# COUNTY COUNCIL'S RESPONSE TO CONSULTATION ON THE FOLLOWING DEVELOPMENT PROPOSAL

**Application no:** 19/00616/OUT-2

**Proposal:** The erection of up to 28 dwellings and associated access

**Location:** OS Parcel 9507 South Of 26 And Adjoining Fewcott Road Fritwell

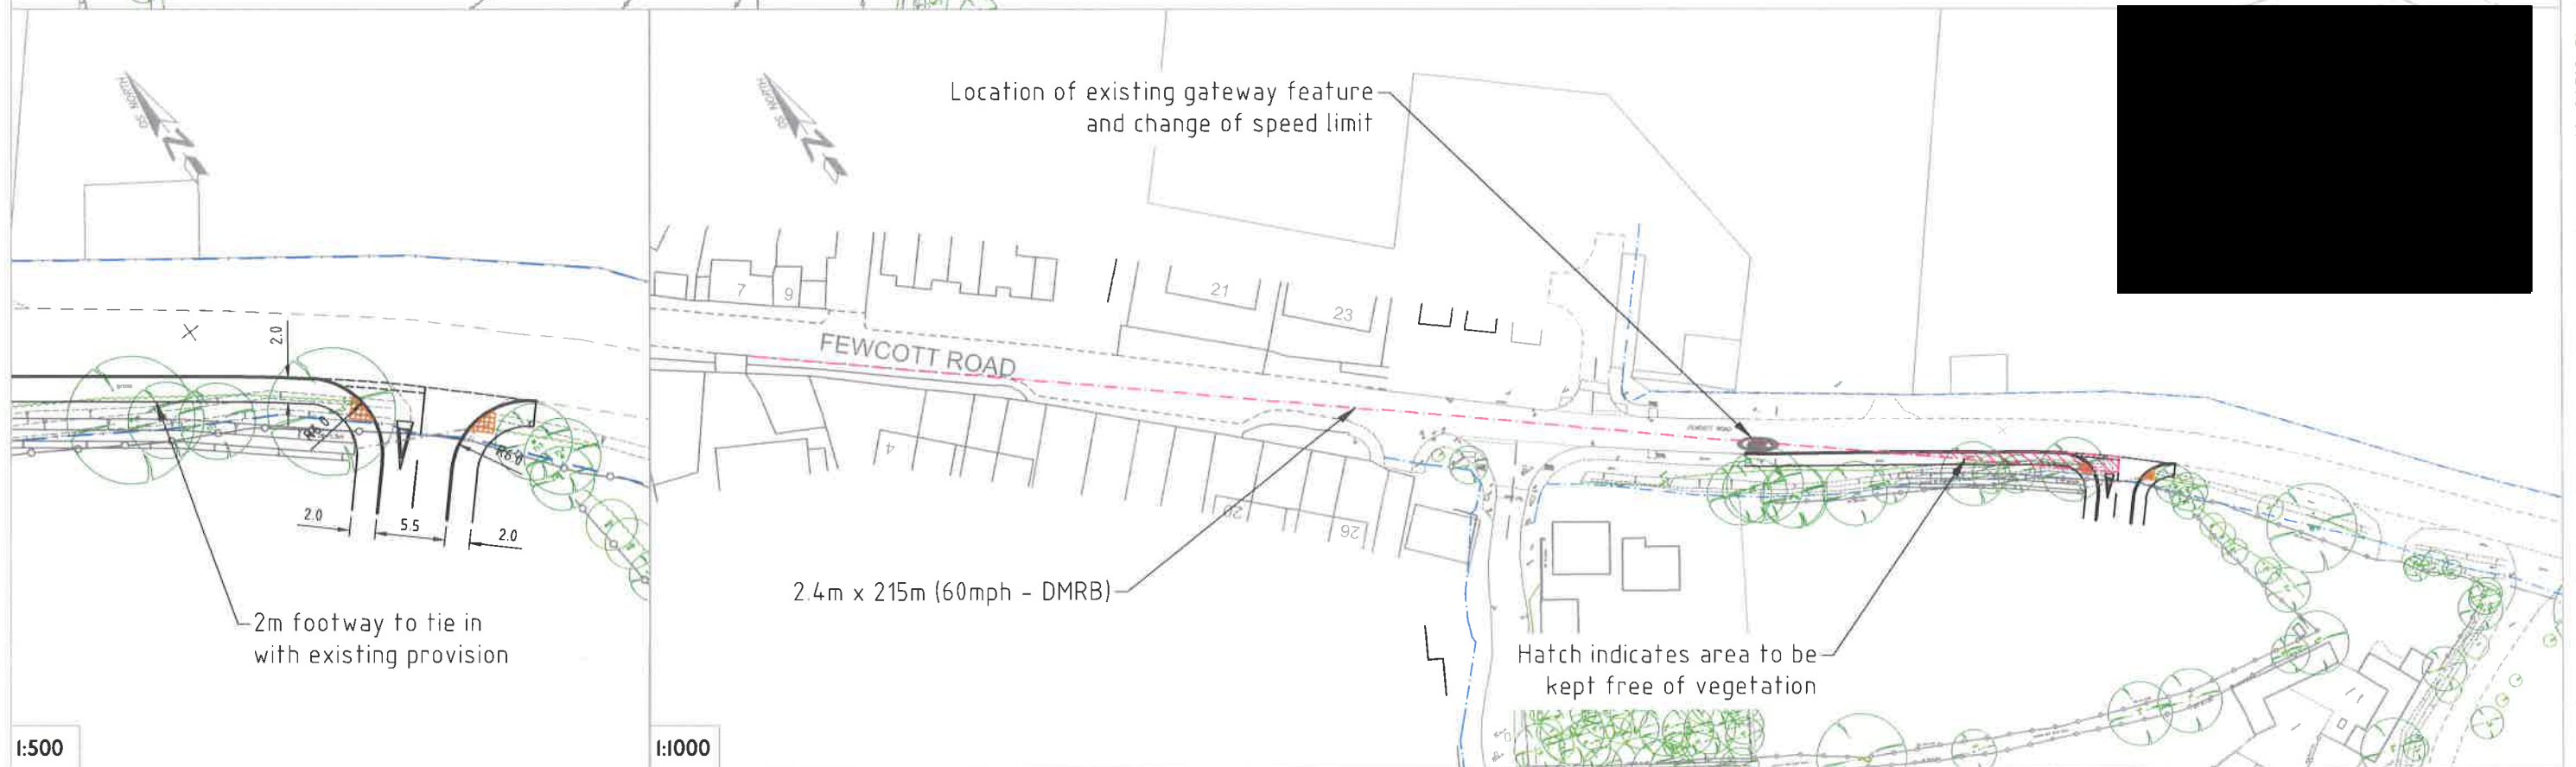
The applicant has provided updated details regarding the site access. This shows that the Manual for Streets (MfS) visibility splays for 30mph (43m) can be achieved. However, it is not considered that the MfS standards are appropriate in this location and that the DMRB visibility splays should be provided. It is not guaranteed that the 30mph speed limit will be successfully extended and therefore the visibility splays should be based on the DMRB standards.

In the previously submitted documents visibility splays of 215m (DMRB standards for 60mph) were provided, the applicant has undertaken speed surveys that show the 85<sup>th</sup> percentile speed at 34.4mph Northbound and 36.7mph Southbound and therefore visibility splays of 120 metres should be provided, as 215m was previously demonstrated this is considered achievable.

The previous issue was land out of the applicants control, however, when inspecting highway records it appears that all of the land is either owned by the applicant, classified as public highway or is the highway ditch. As part of the S278 agreement to create the access, a part of this ditch would need to become within the applicants control through land registry. After consultation with the road agreements engineer it is considered that this can be extended to contain the land required for the 120m visibility splays in addition.

The application includes alterations to the highway directly in front of the application site, this includes extending the 30mph speed limit, new VAS speed limit sign and relocation of gateway and dragons teeth on carriageway. This will be done via S278 agreement and will require consultation.
